Application by Highways England for the M25 Junction 28 Project

The Examining Authority's Further Written Questions and requests for information (WQ2)

Issued on Thursday 25 March 2021

Client		Project		GROVE FARM ACCESS, JUNCTION 28 M25 NORTHBOUND SLIP LANE	
MR L JONES & MRS K JONES		Title		ACCESS ALTERATIONS TO GROVE FARM	
Status	Drawn	Scale	Sheet Size	Date	Drawing No.
FOR APPROVAL	PL	1:1000	A3	JAN 2021	REDW-3396-110
				Rev

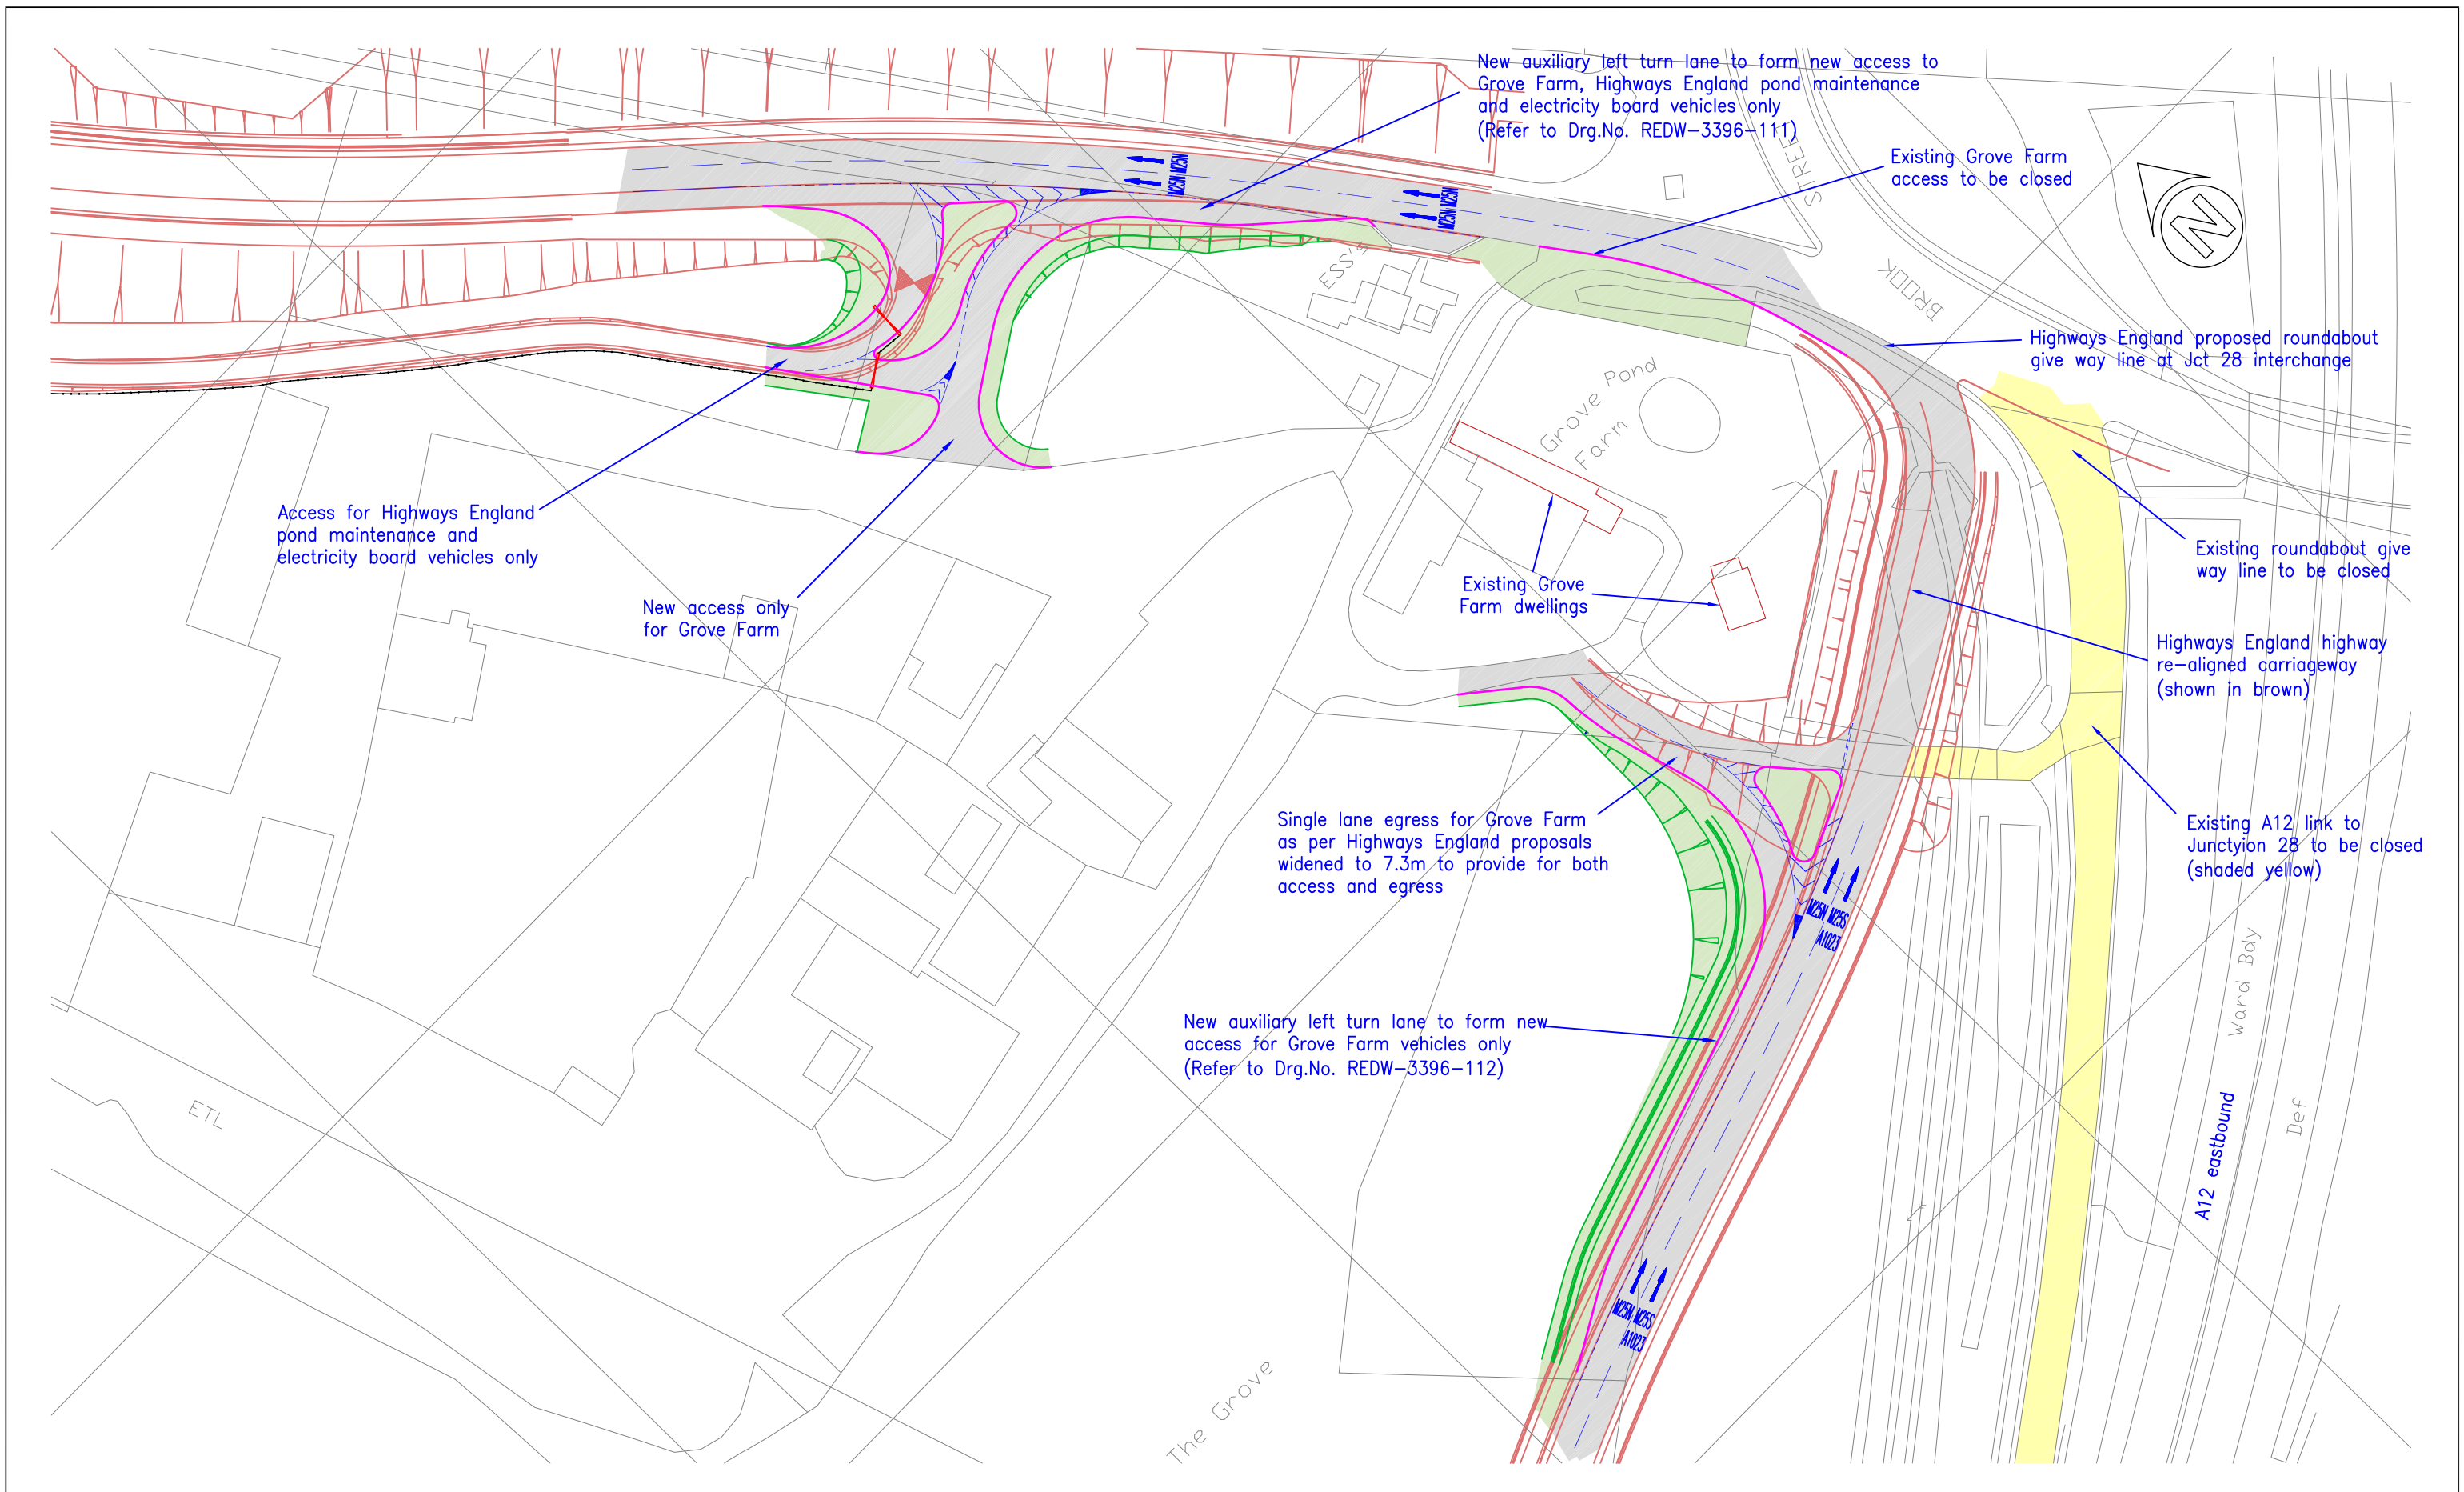
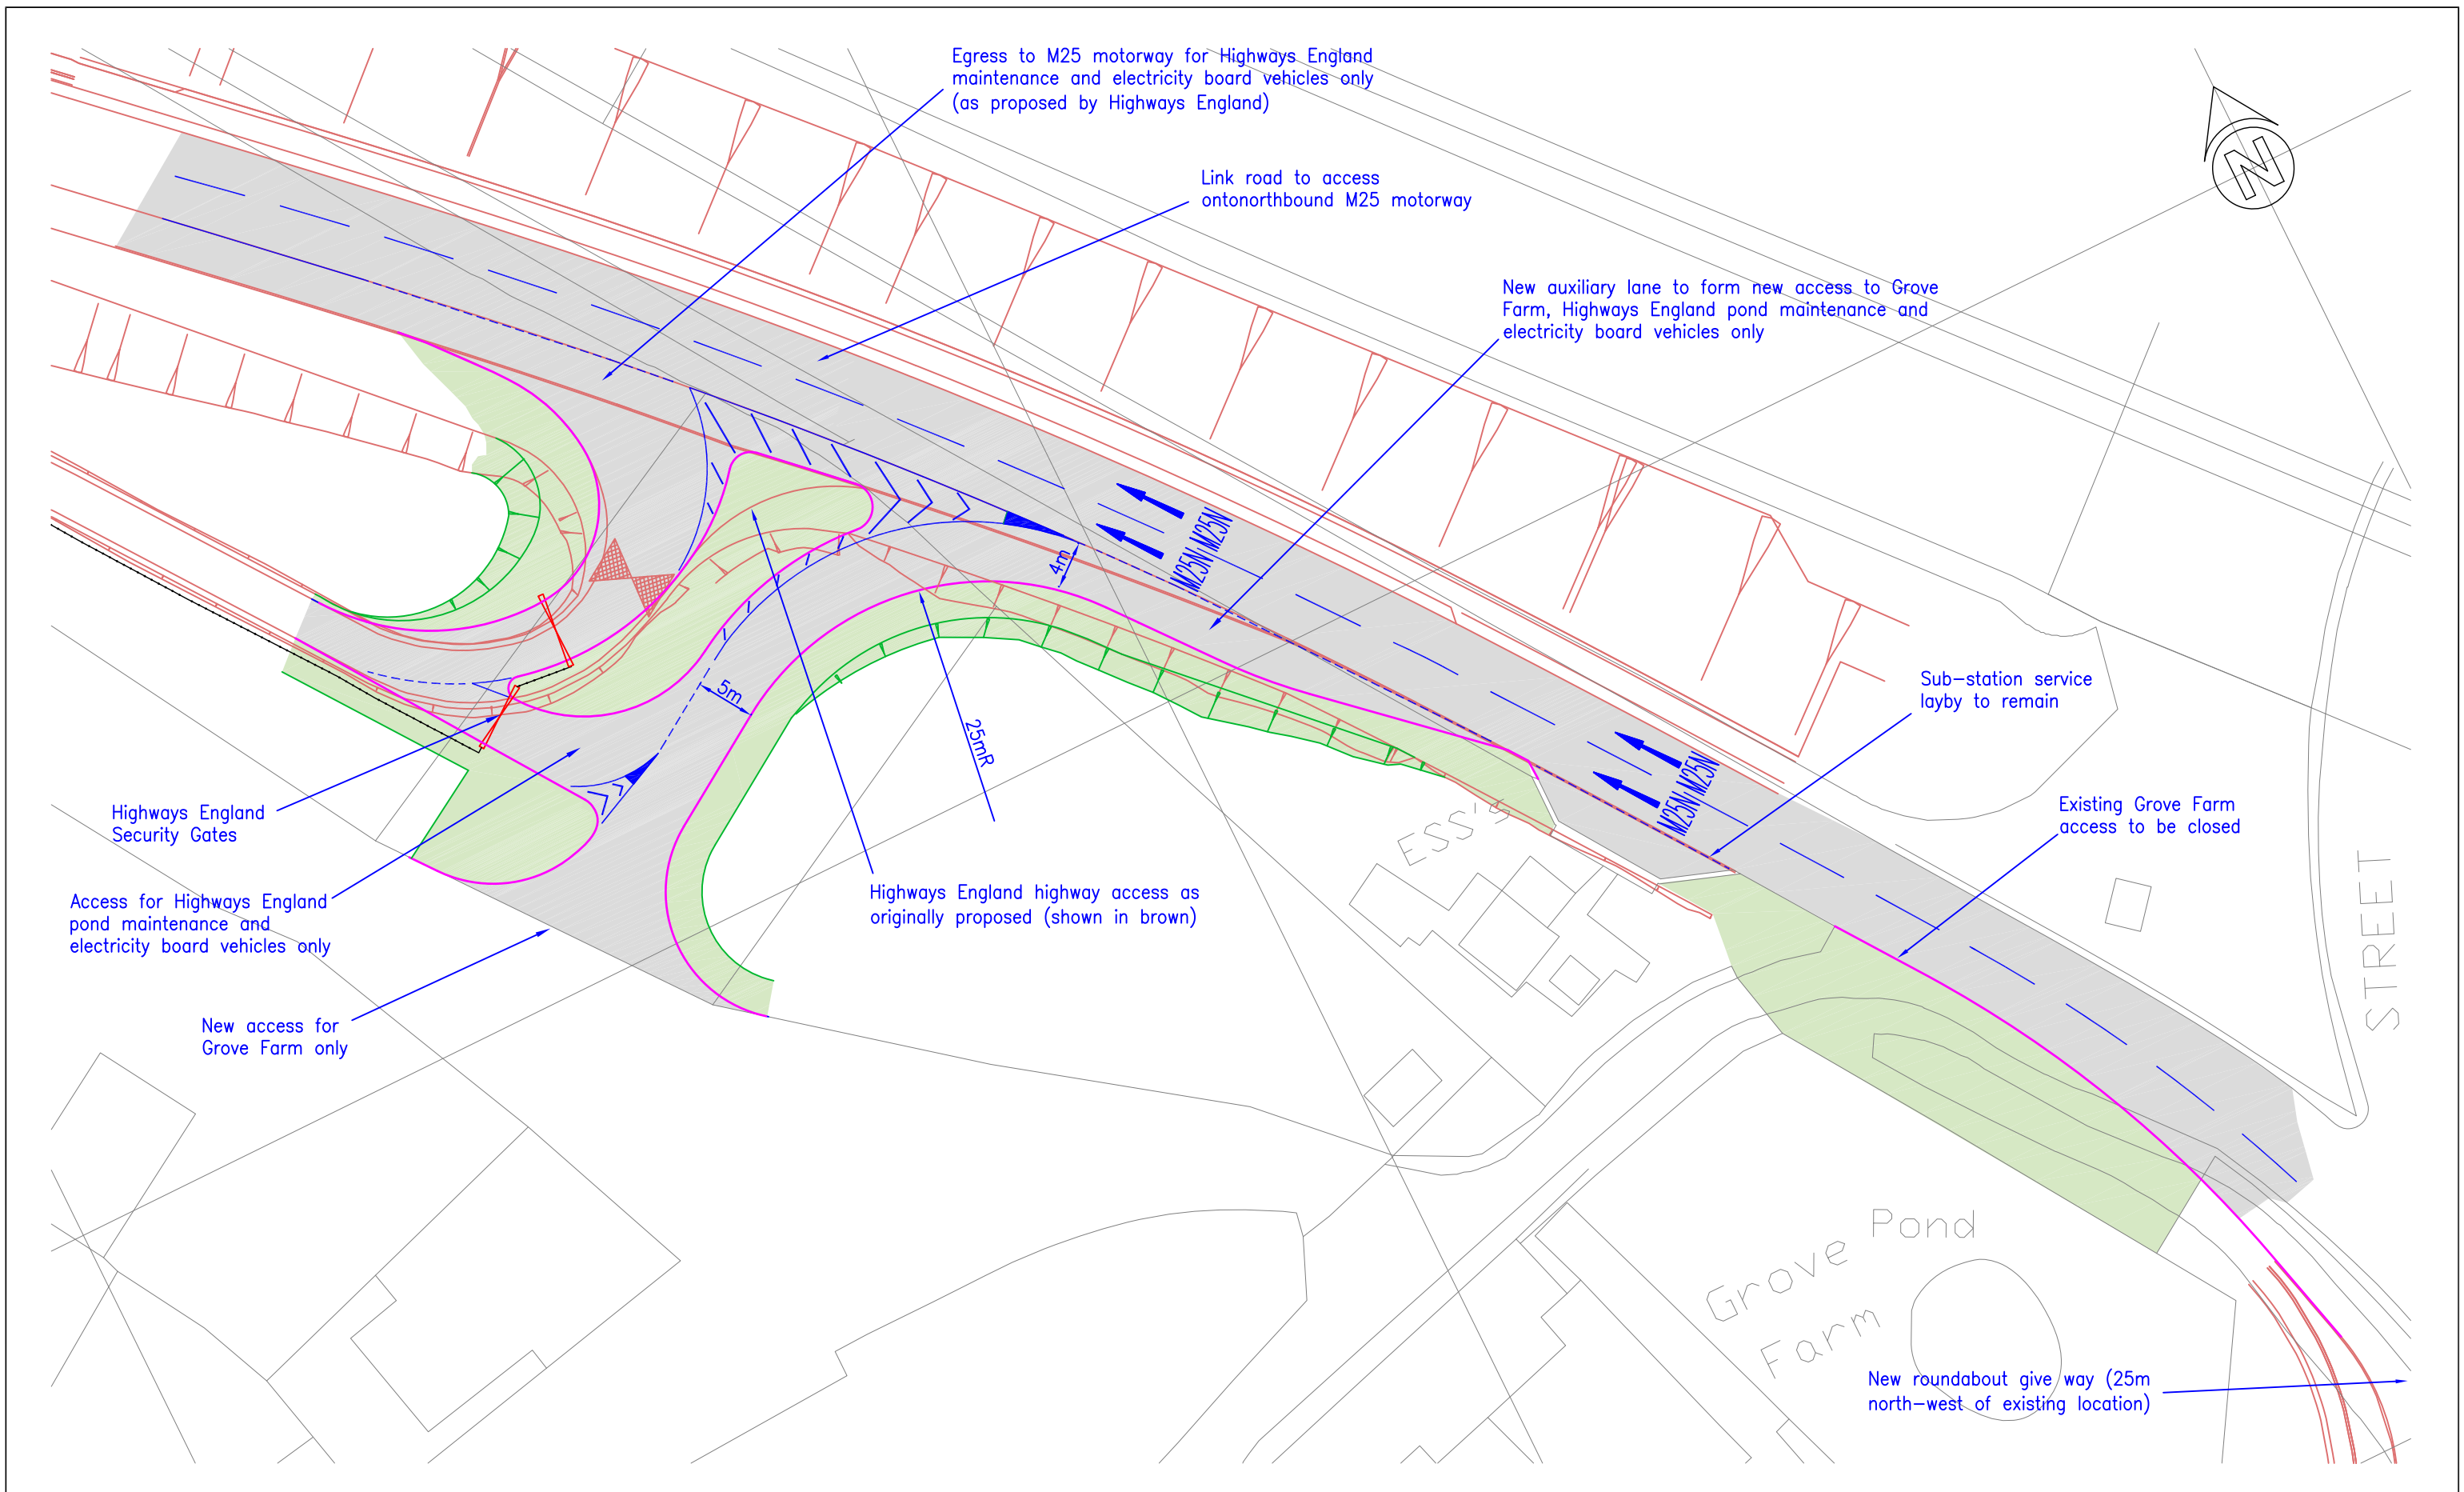
TA 2.3	<i>Proposed Access / Egress at Grove Farm</i> The Applicant	The representatives of Mr & Mrs Jones submitted revised proposals at Deadline 4 [REP4-036] for access / egress to and from their property. Provide comments on these proposals.
